CITY OF ALBUQUERQUE

August 3, 2023

Re: Albuquerque RV and Boat Storage
2201 Vista Oriente NW
Traffic Circulation Layout
Architect's Stamp 07-20-23 (H10-D030)

TRAFFIC CONTROL LAYOUT

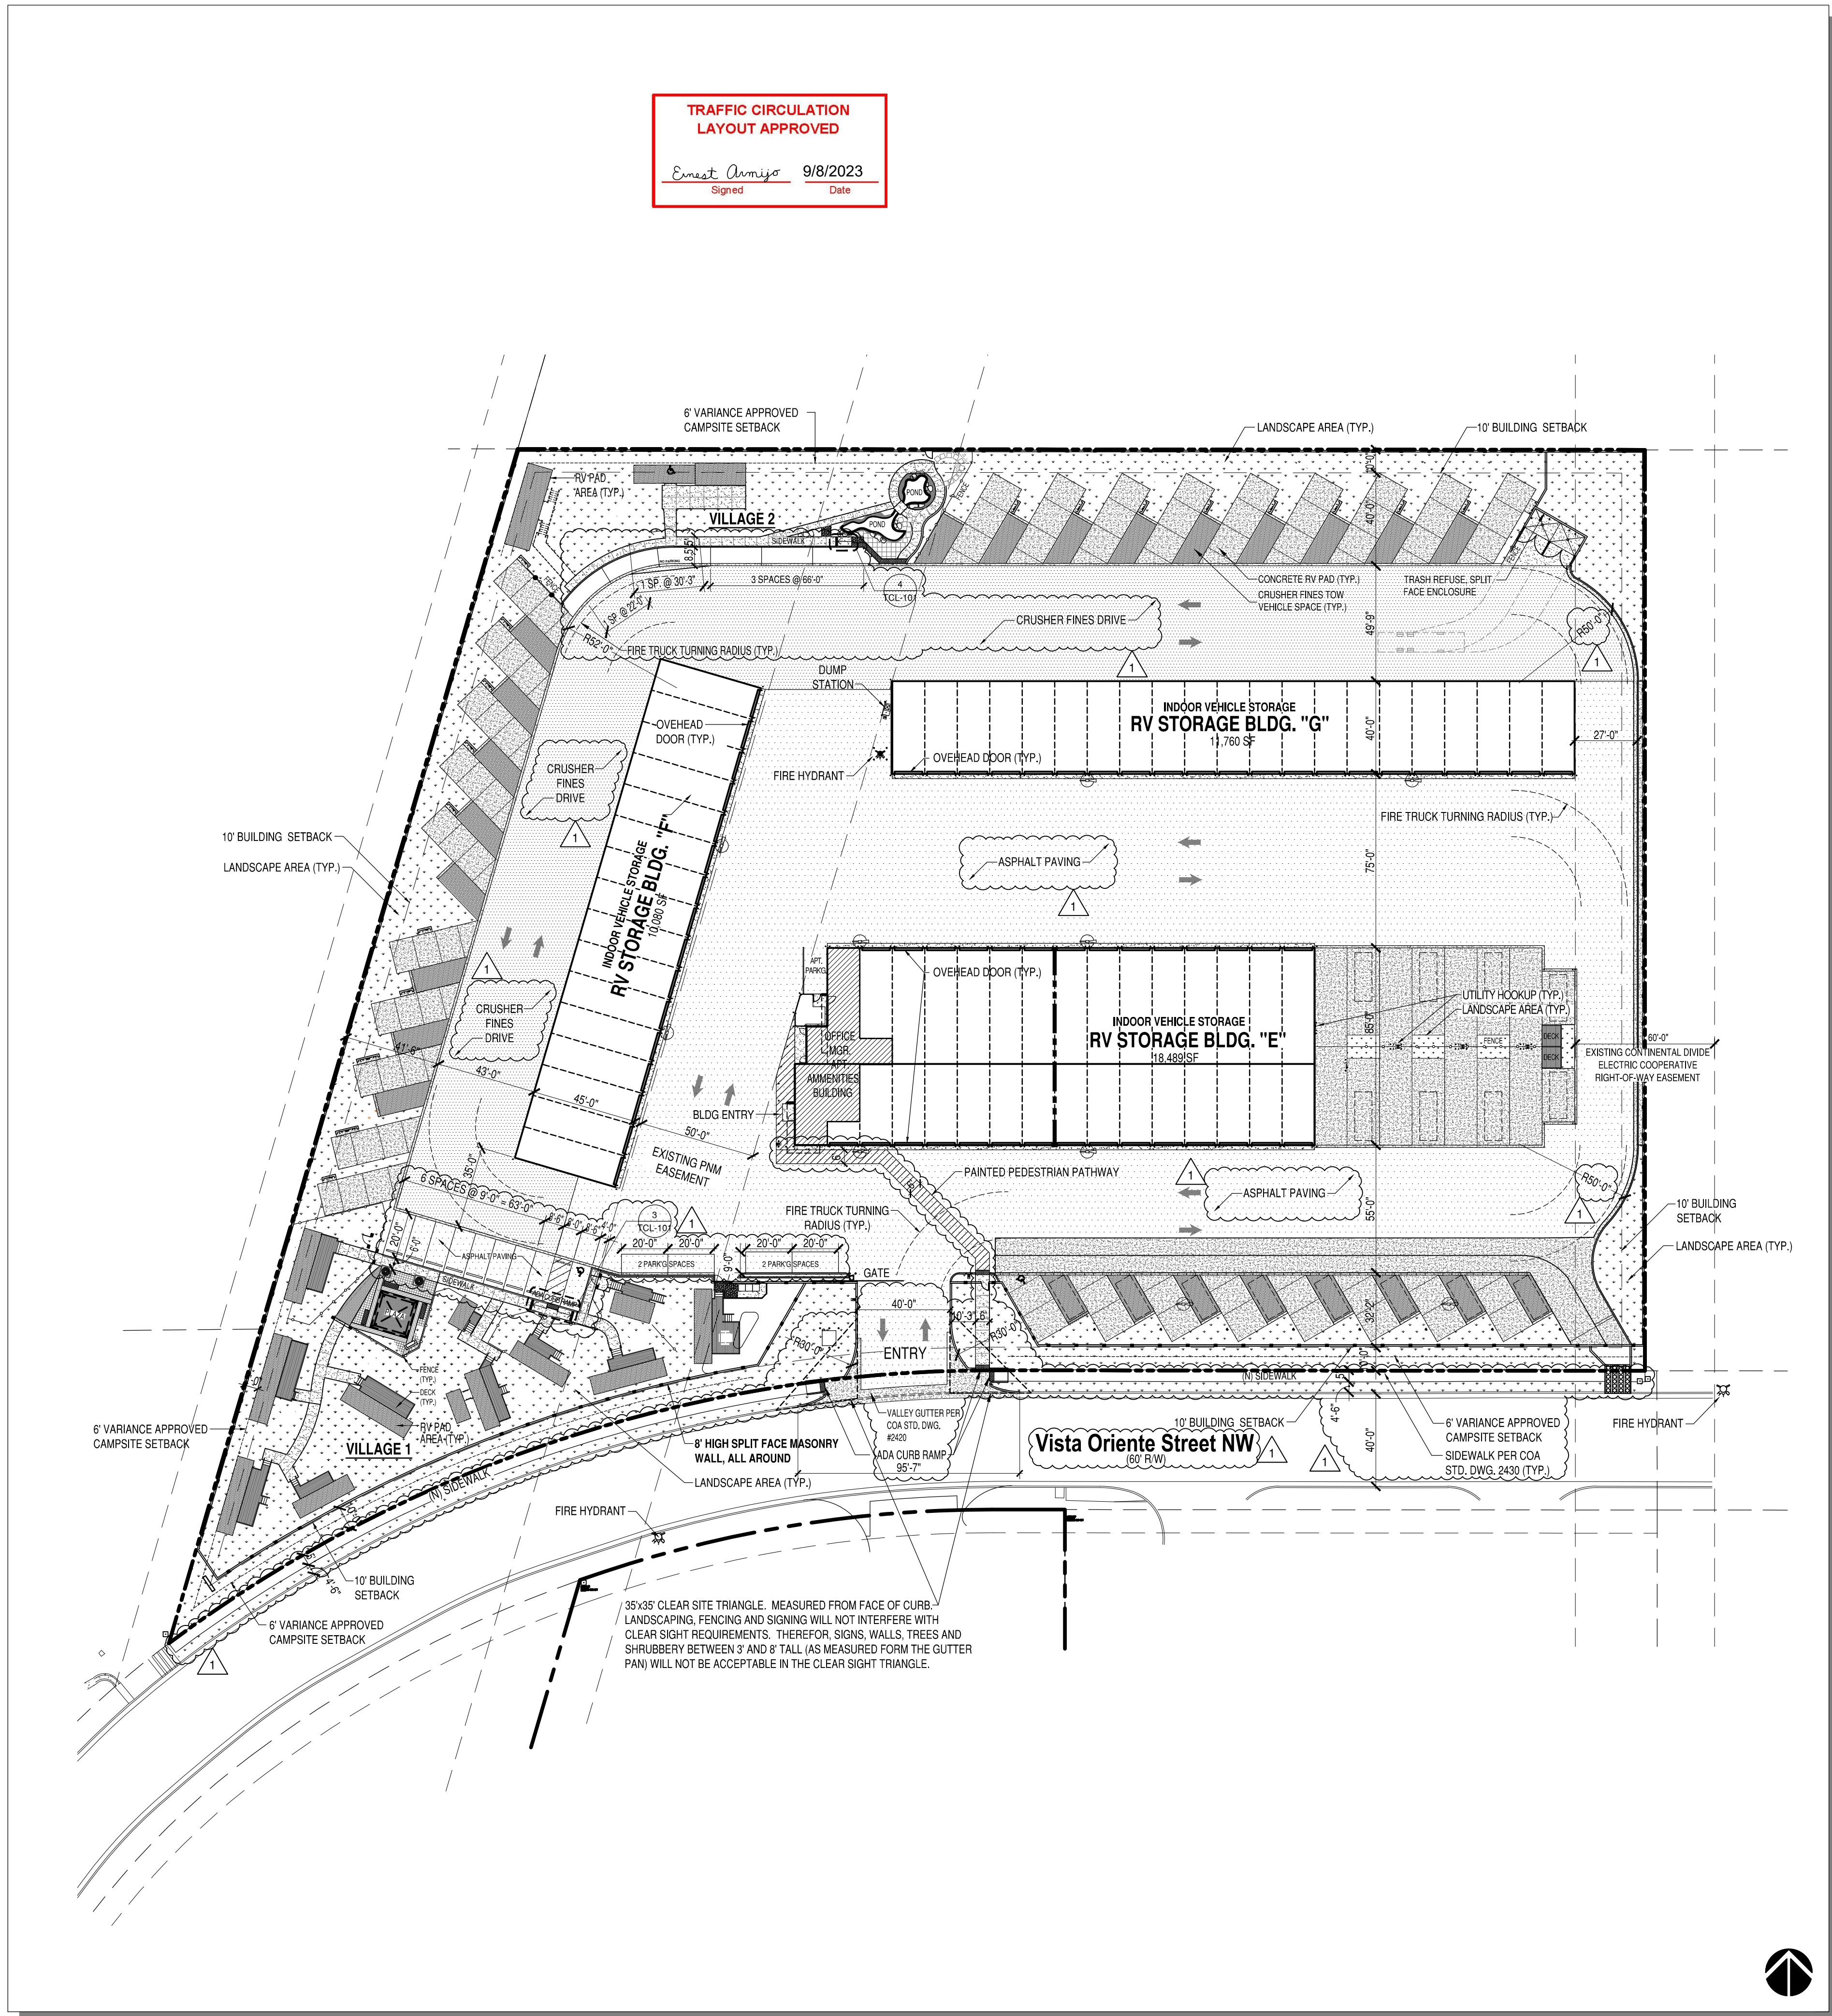
1. Identify the right of way width, medians, curb cuts, and street widths on Vista Oriente NW.
2. Provide details for the proposed sidewalk. Please note that per DPM requirements a minimum 5 ft. wide sidewalk and 5-6 ft. wide buffer should be developed, and reference COA std dwg 2430.
3. Please show on the site plan the site access width, radii, and provide access's details, or reference COA std dwg.
4. Provide details for all the proposed interior ADA ramps.
5. Please list the width and length for all proposed parking spaces. Some dimensions are not shown.
6. The minimum parking stall dimensions are:

7. The ADA accessible spaces must include an access aisle. Van accessible aisles should be 8ft wide; all others should be 5ft wide.
8. The ADA access aisles shall have the words **"NO PARKING"** in capital letters, each of which shall be at least one foot high and at least two inches wide, placed at the rear of the parking space so as to be close to where an adjacent vehicle's rear tire would be placed. (66-1-4.1. B NMSA 1978)

9. Per the IDO, a 6 ft. wide ADA accessible pedestrian pathway is required from the public sidewalk to the building entrances. Please clearly show this pathway and provide details.

10. Per DPM, a 6 ft. wide ADA accessible pedestrian pathway is required from the ADA parking stall access aisles to the building entrances. Please clearly show this pathway and provide details.

11. ADA accessible pedestrian pathway should not be placed behind parking space or adjacent to a vehicular way. Vehicle and pedestrian/wheel chair conflicts should be avoided as much as possible.

12. It is not apparent what type of pavement surface is being proposed. A hard driving surface will be required as part of this proposed project for parking area and drive aisles.

13. Work within the public right of way requires a work order with DRC approved plans.
14. Please add a note on the plan stating "All improvements located in the Right of Way must be included on the work order."
